**New Berrima Clay-Shale Quarry (PA08_0212 Mod 1)
Proposed Modification**

Attachment A

New Berrima Clay-Shale Quarry (PA08_0212 Mod 1) Proposed Modification Comment / Additional comments by NSW Office of Water

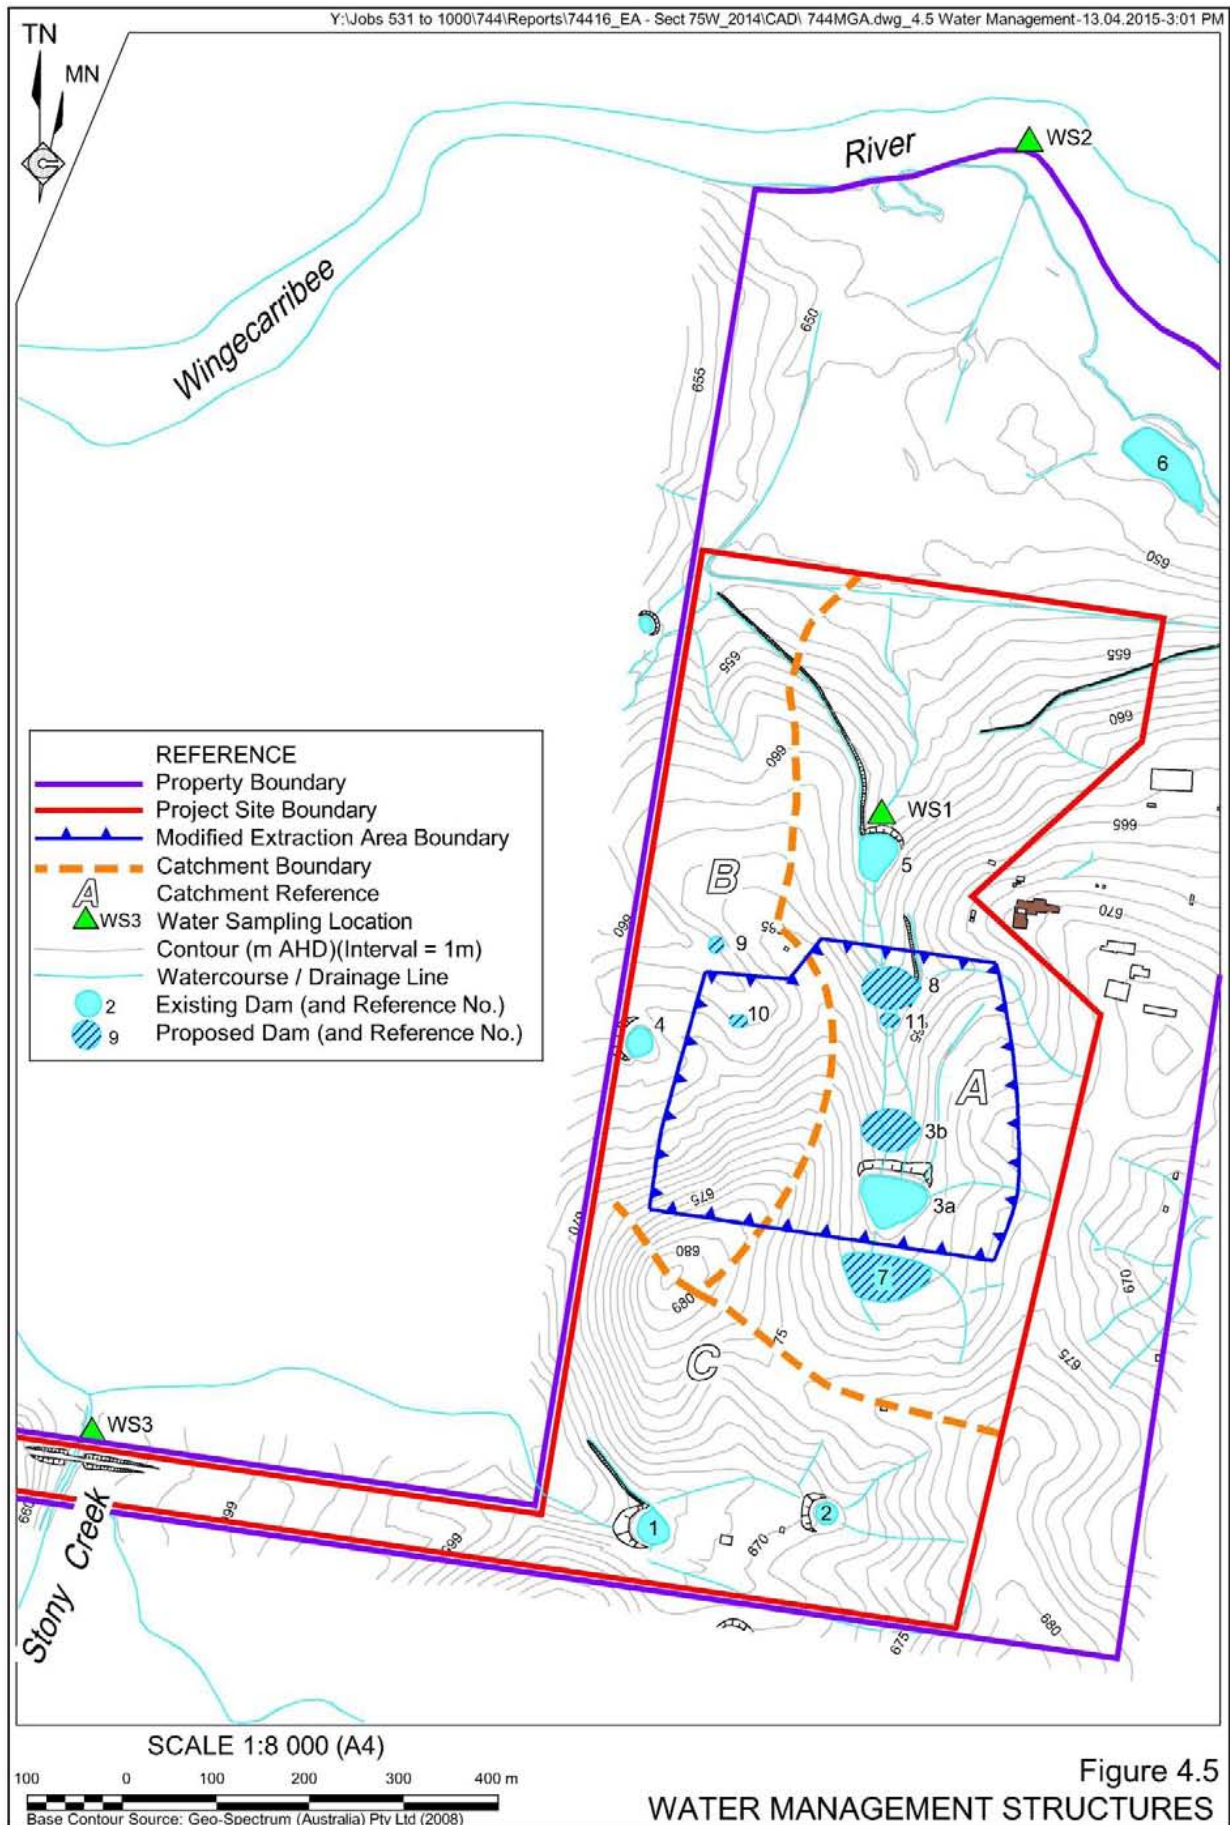
Figure 4.5 in the EA shows the quarry modification will remove 1st and 2nd order watercourses on the site but Appendix 6 indicates that within Catchment A where excavation is proposed there are no defined channels and they are open grassy depressions (page A6-10). The final landform (Figure 2.7) shows the upstream sections of these watercourses/depressions will flow into a rectangular basin (page 29). As surface runoff from the project site currently flows to the Wingecarribee River, the Office of Water requests consideration as to whether it is possible to divert the watercourses/depressions around the rectangular basin so the runoff flows to the river rather than into the basin once quarrying is completed.

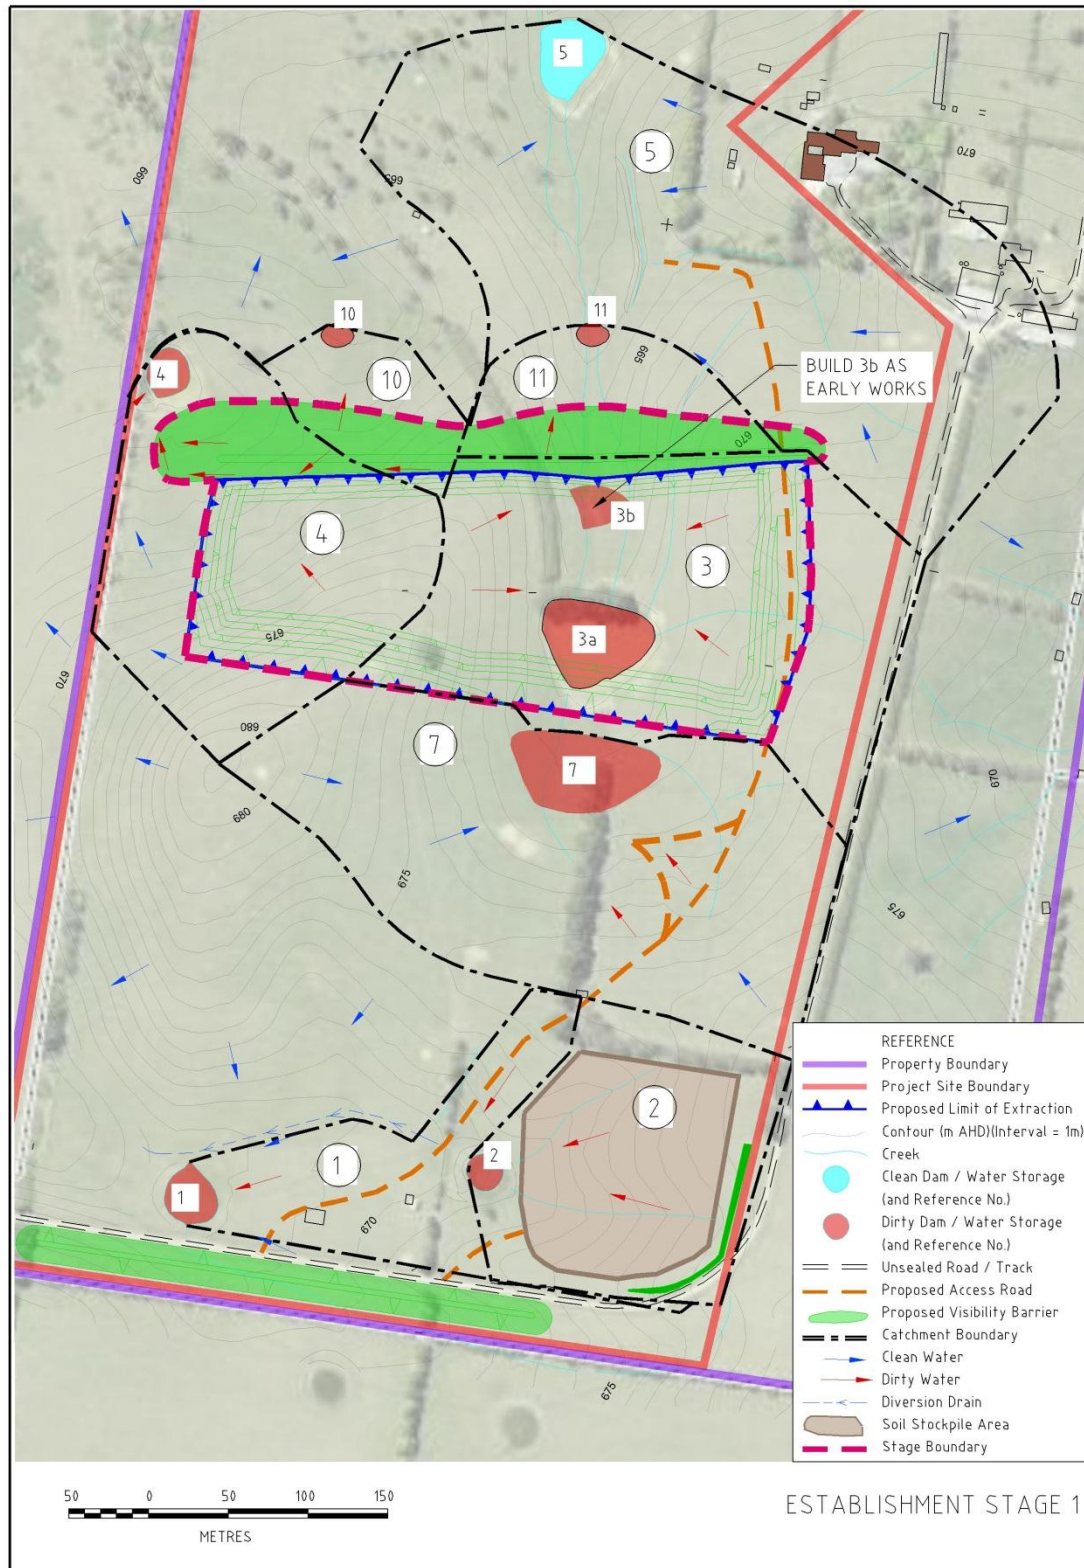
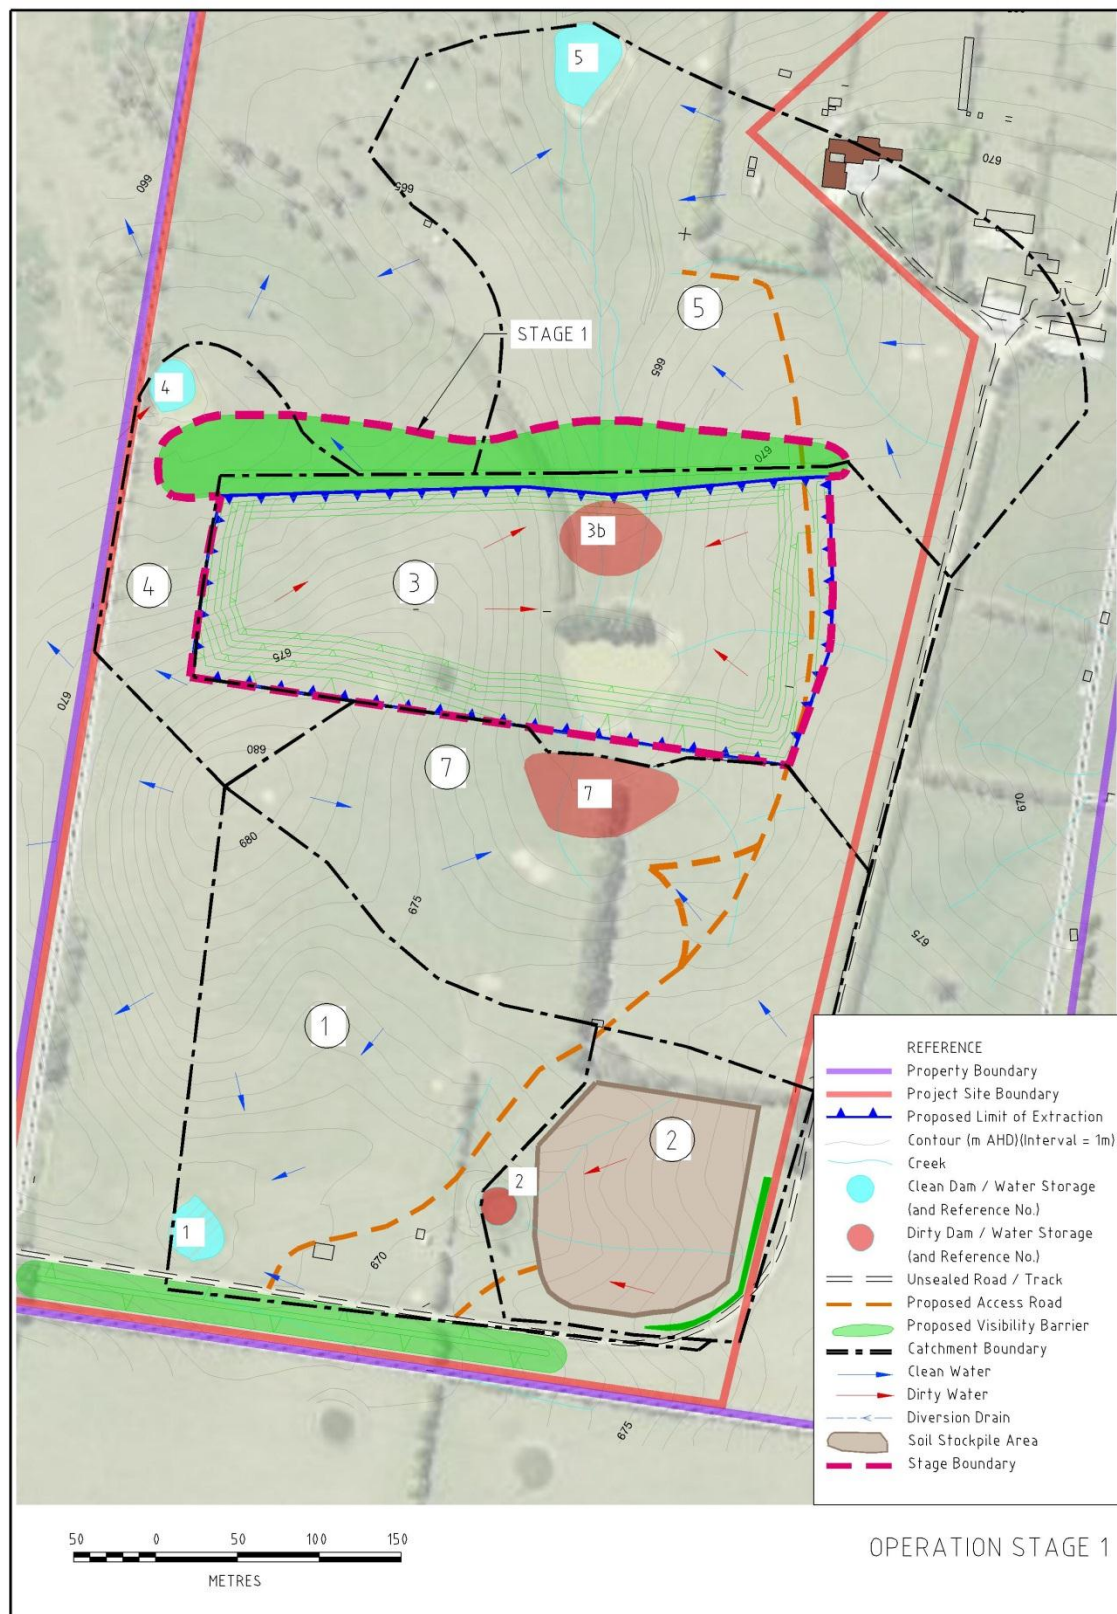
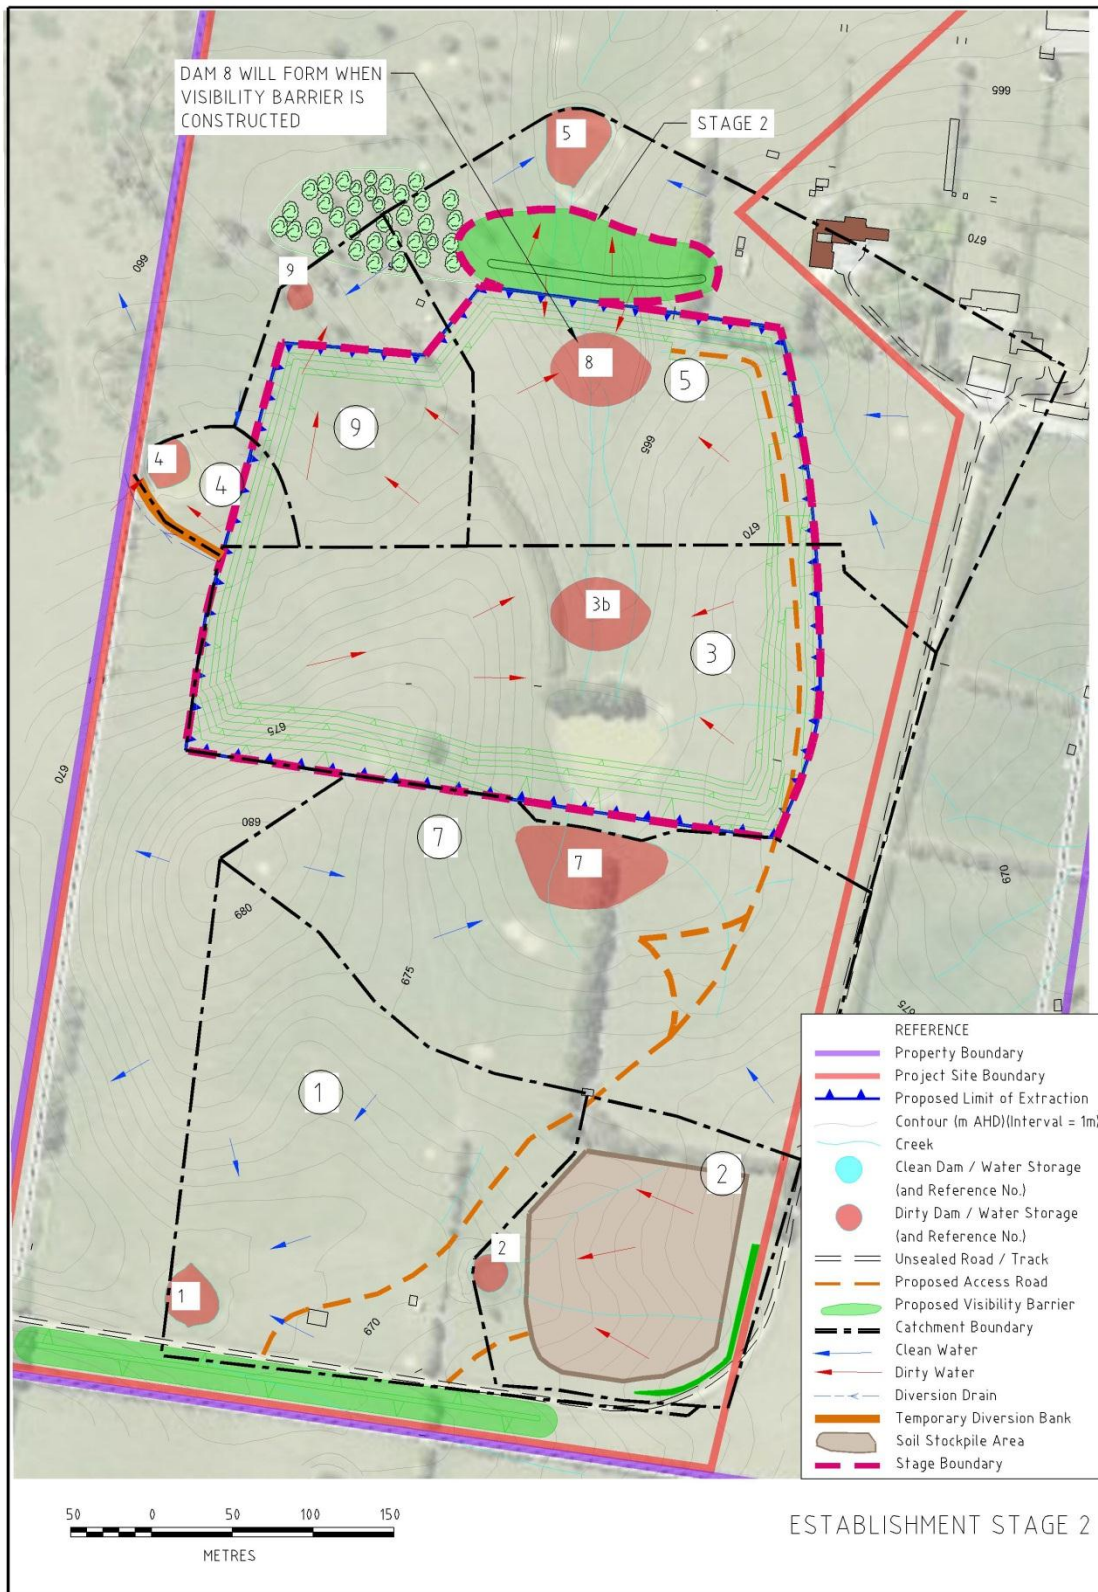
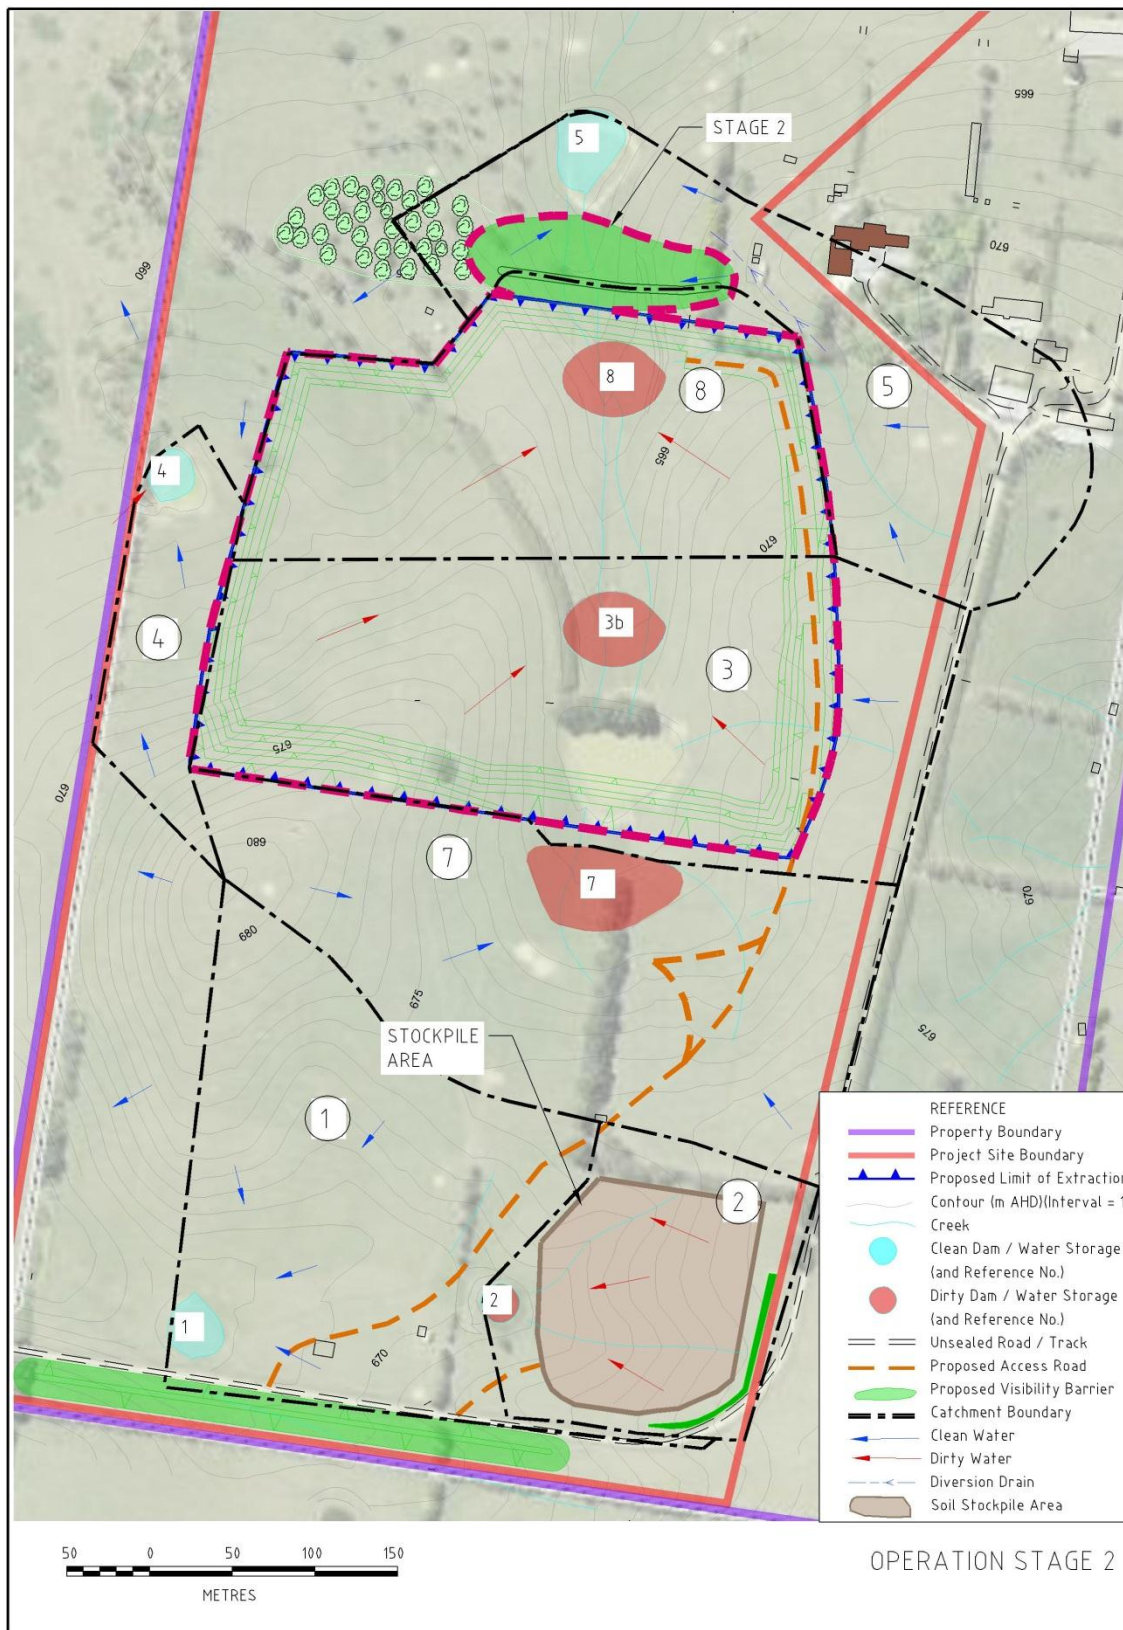
Table 8 of Appendix 6 indicates Dams 1 and 4 will not be used for re-use when clean (see pages 22-23) but Section 5.2 notes they will be used for agricultural purposes (page 15). Clarification is required on this.

Table 8 indicates the capacity of Dam 1 is 1.43 ML and Dam 4 will be enlarged to 1.4 ML (see Appendix 6, pages 22 and 23). It is unclear how the combined capacity of 2.12 ML has been derived for Dams 1 and 4. Based on Table 8, the combined capacity of Dams 1 and 4 appears to be 2.83 ML rather than 2.12 ML (see Section 5.2 of Appendix 6, page 15 and 16).

Appendix 6 outlines Dam 7 has a total volume of 6.94 ML and notes 5.4 ML is to be used for storm capture and 1.54 ML is to be used for dust suppression and washdown water (pages 16 and 23). Appendix 6 only includes 1.54 ML as part of the HR calculation but Schedule 1 (2) of the *Water Management (General) Regulation 2011* specifies that to be an excluded work the dam

needs to be "solely for flood detention and mitigation" and (a) from which no water is reticulated. In order that the Office of Water can be satisfied that the 5.4 ML storm capture component does not require licensing, a commitment or condition preventing extraction from the dam when it is above the full storage level of 1.54 ML is recommended.
